Our ref: DOC21/973453
Senders ref: SSI-19238057

Subject: EES flood comments on Environmental Impact Statement for Sydney Metro West Stage 2 Project – The Bays to Sydney CBD - SSI-19238057

- Environmental Impact Statement - Chapter 17 - Hydrology and flooding
- EIS Technical Paper 9 Hydrology and flooding - Part 1 Main Report to Appendix B

Figure A3 Difference map

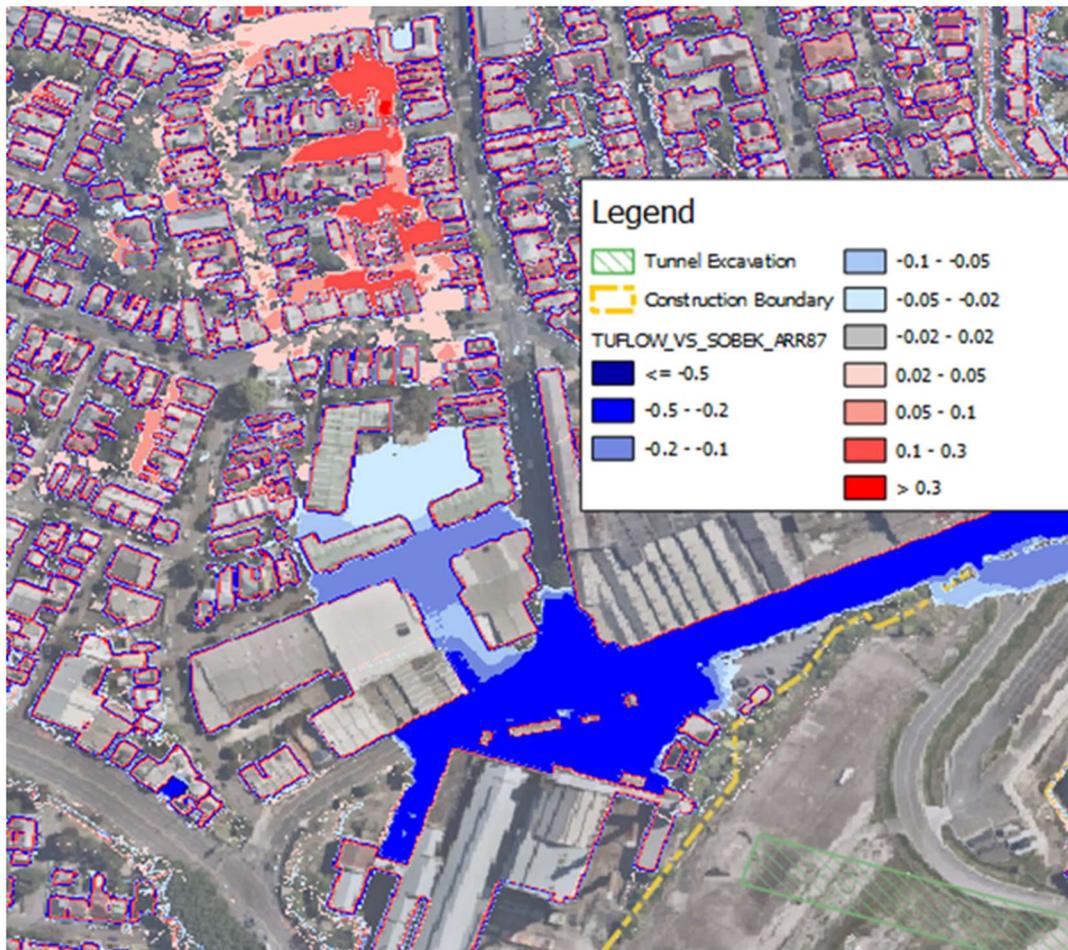
A TUFLOW Model has been developed for the assessment of flooding impacts at The Bays. The model has been compared with the previously developed Sobek Model for the Leichhardt Flood Study by Inner West Council (2015). A comparative assessment of the outputs from these models has been undertaken to evaluate the consistency and reliability of these models in evaluating the baseline flooding conditions. The outputs are found to be comparable although predicted water levels from the TUFLOW Model are less than the Sobek Model in the vicinity of the proposed construction site at The Bays. The Hunter Street and Pyrmont sites used TUFLOW models developed from adopted studies by the Council of the City of Sydney.

TITLE
 Figure B-1
 1% AEP Baseline Stage Depth

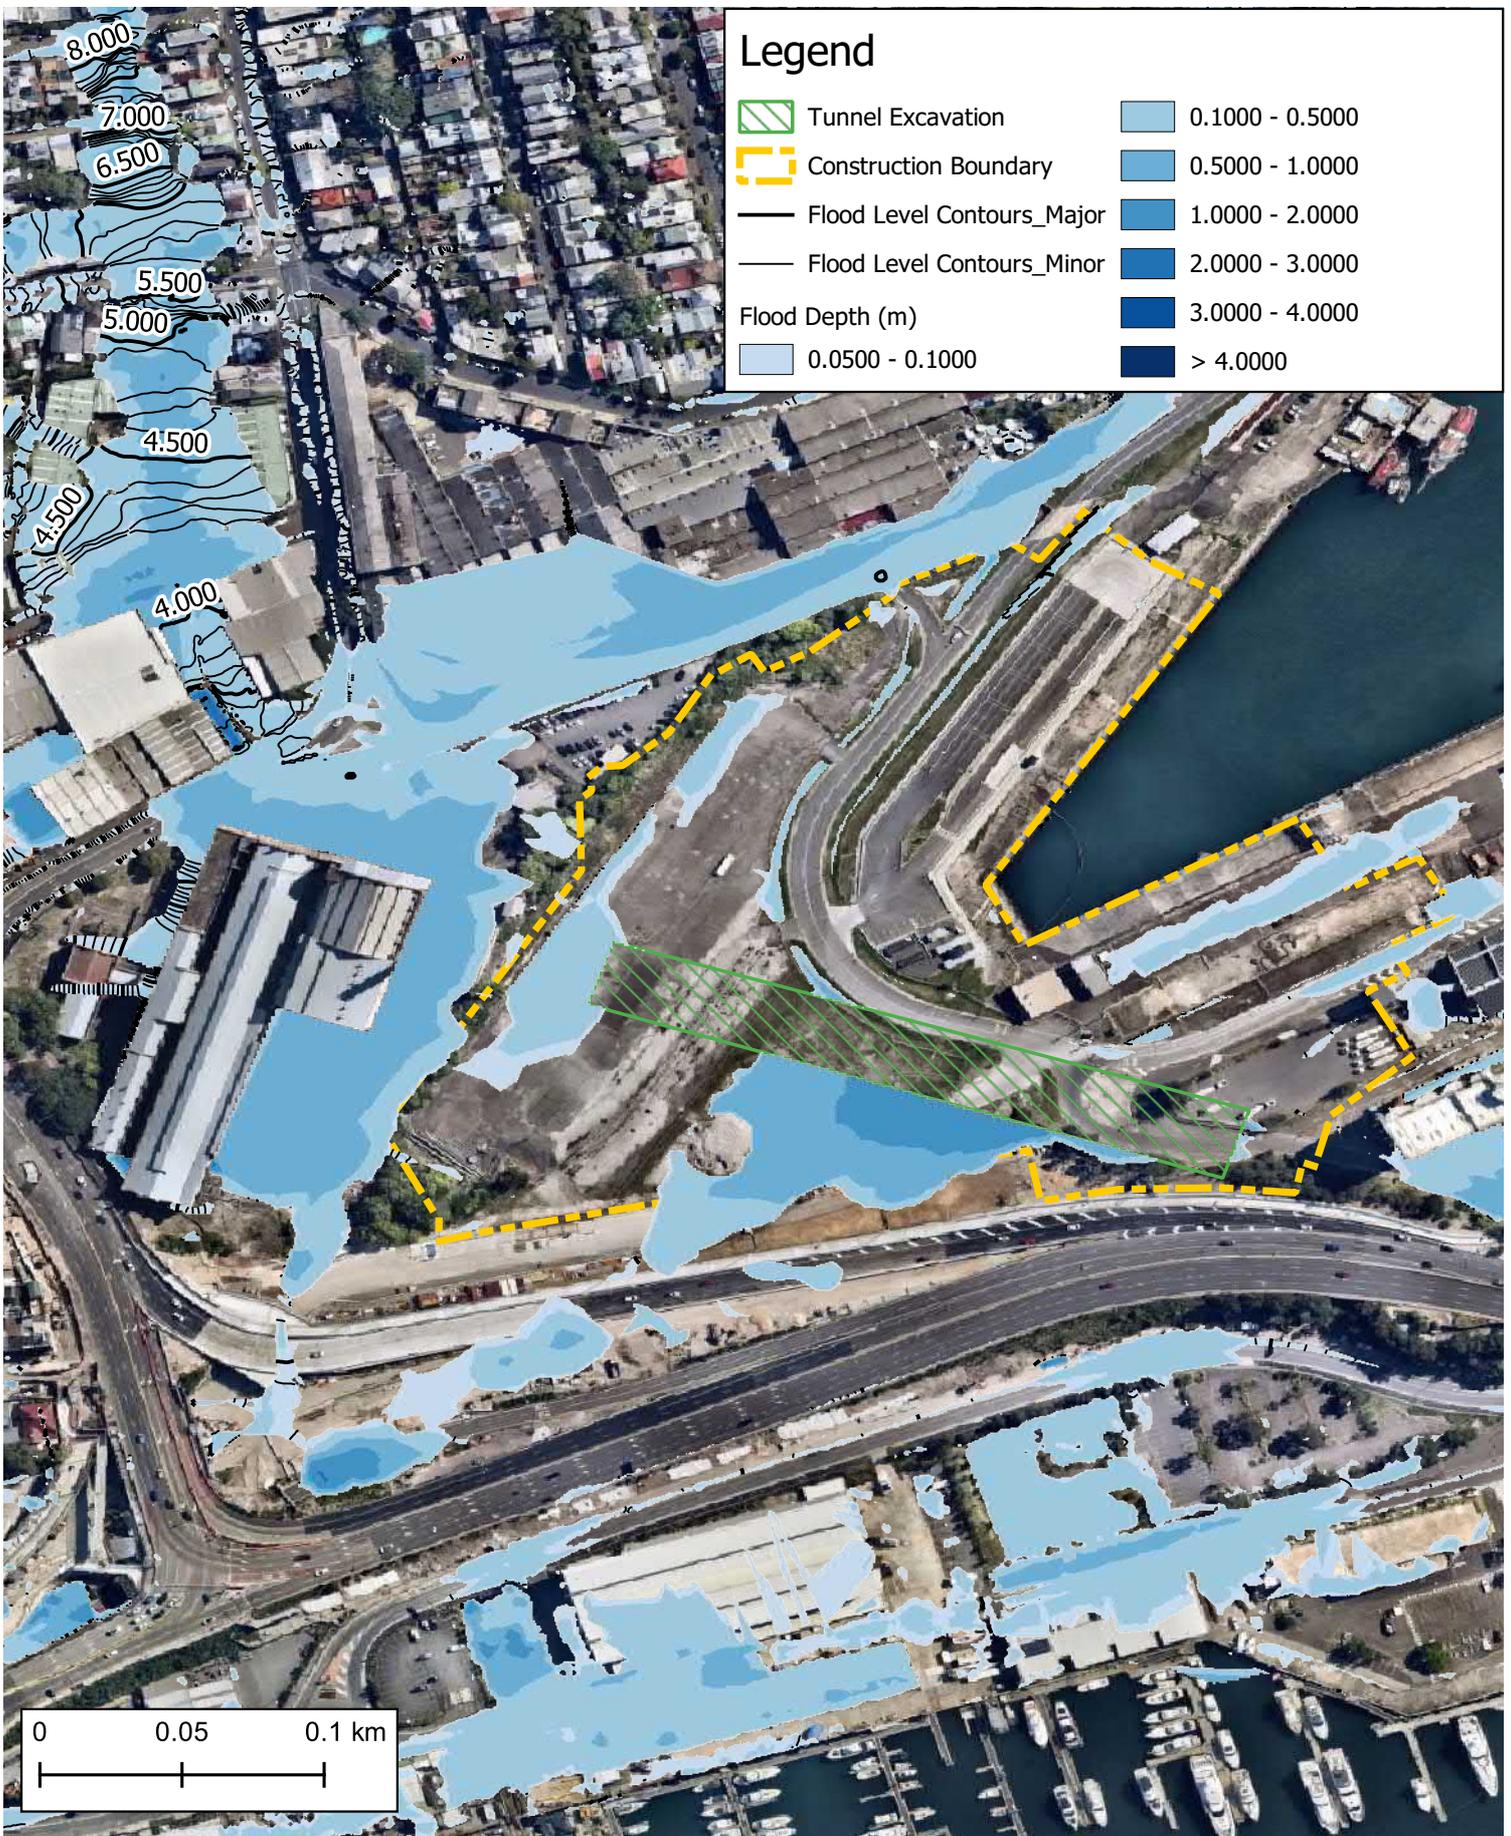
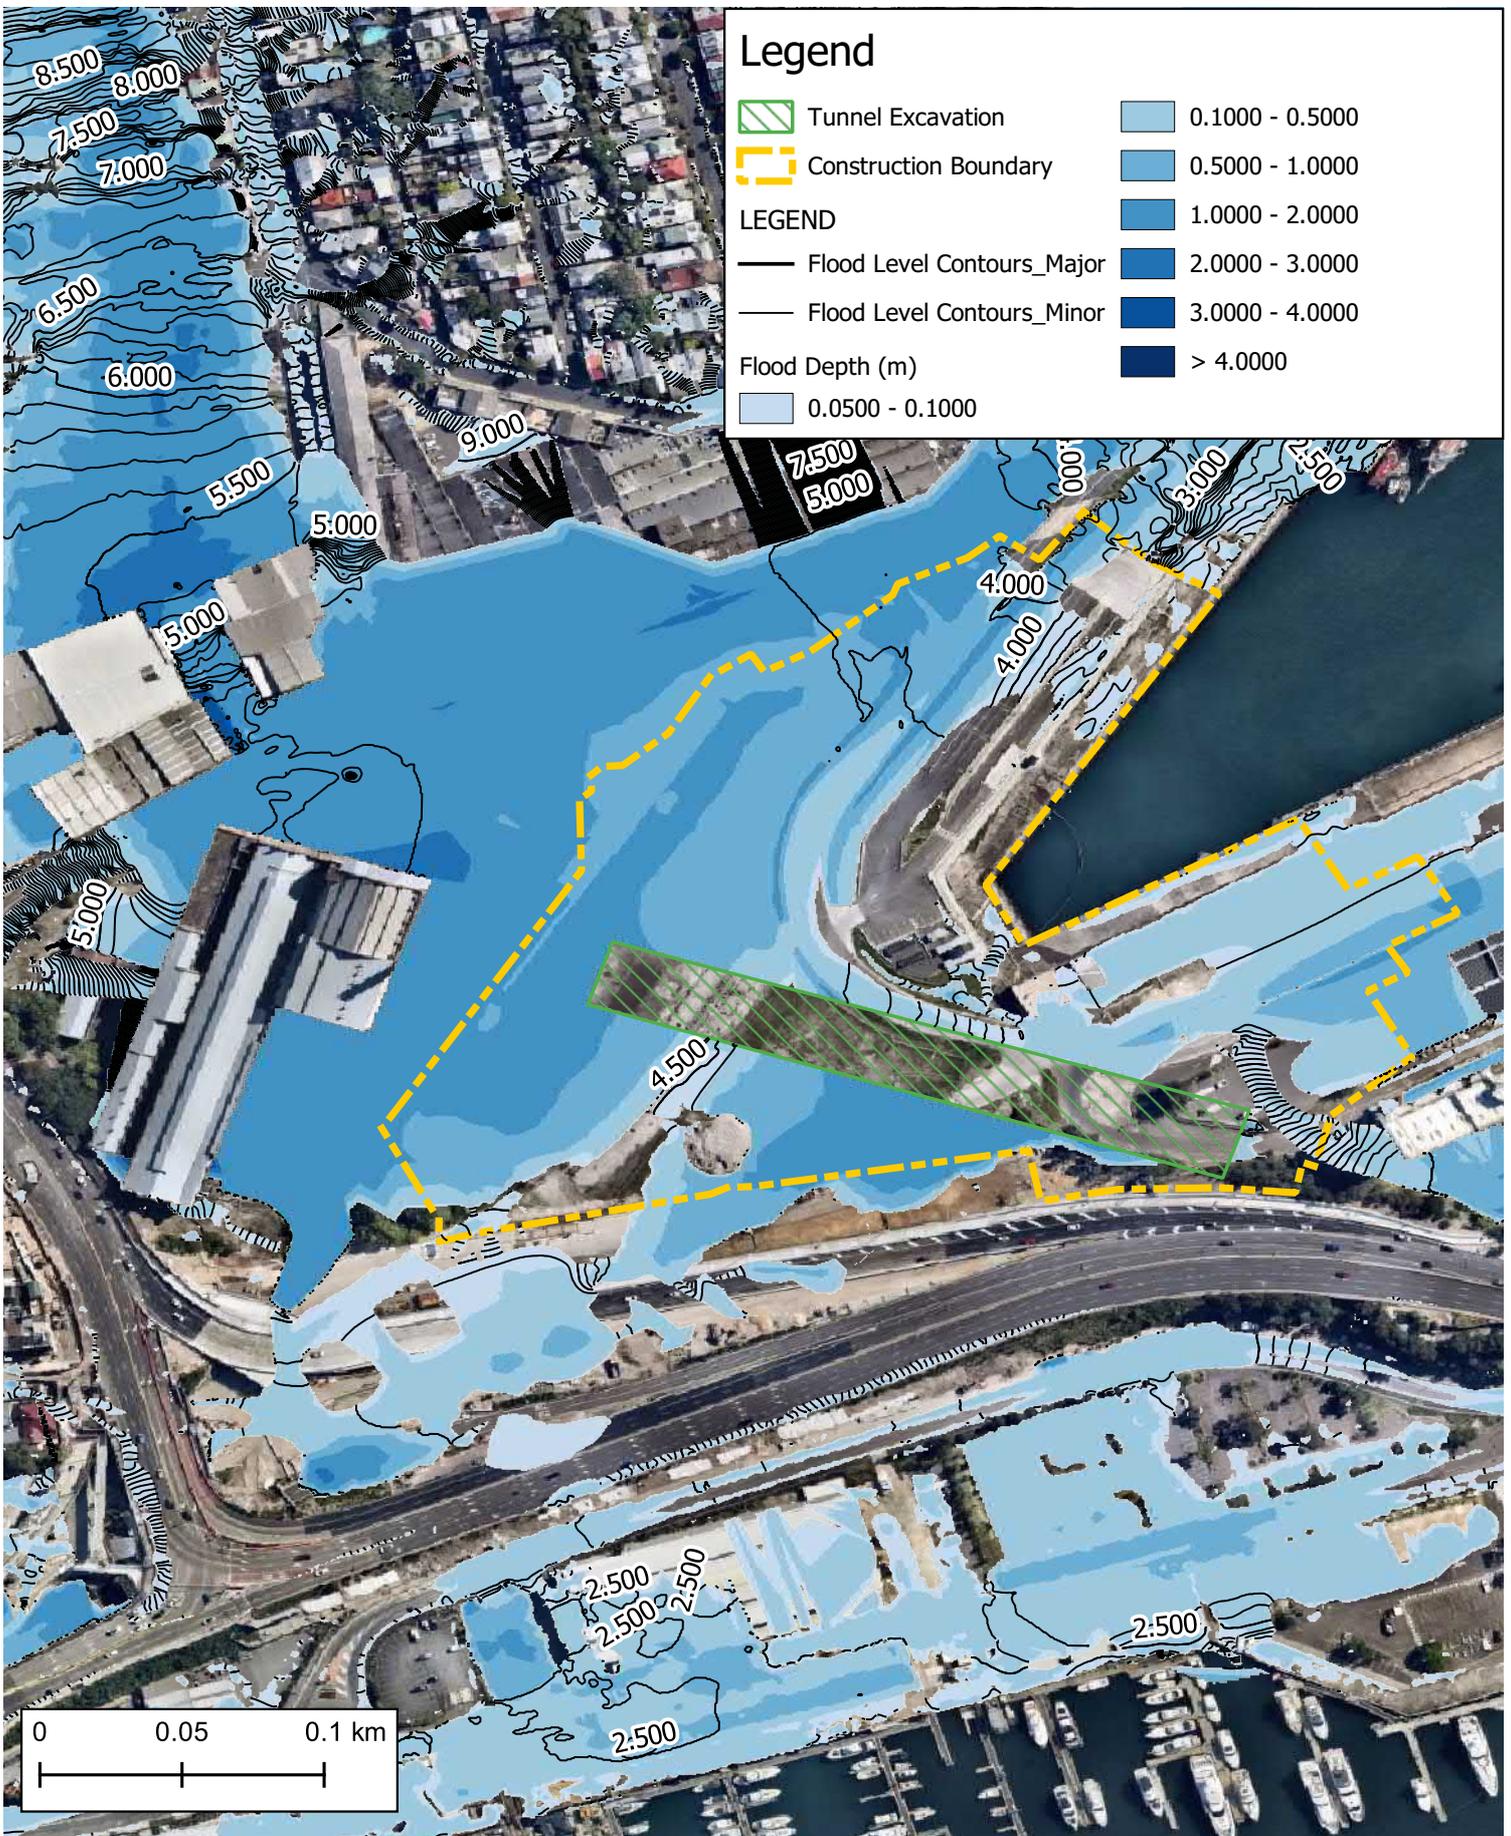
For clarity, EES requests that future mapping of flood depths be revised so that the depth at a given location can be easily interpreted using the legend. The figures presented use so many similar shades of blue that it is very difficult to distinguish between them on the map. An alternative would be to mark and annotate sample and maximum depths at relevant locations.
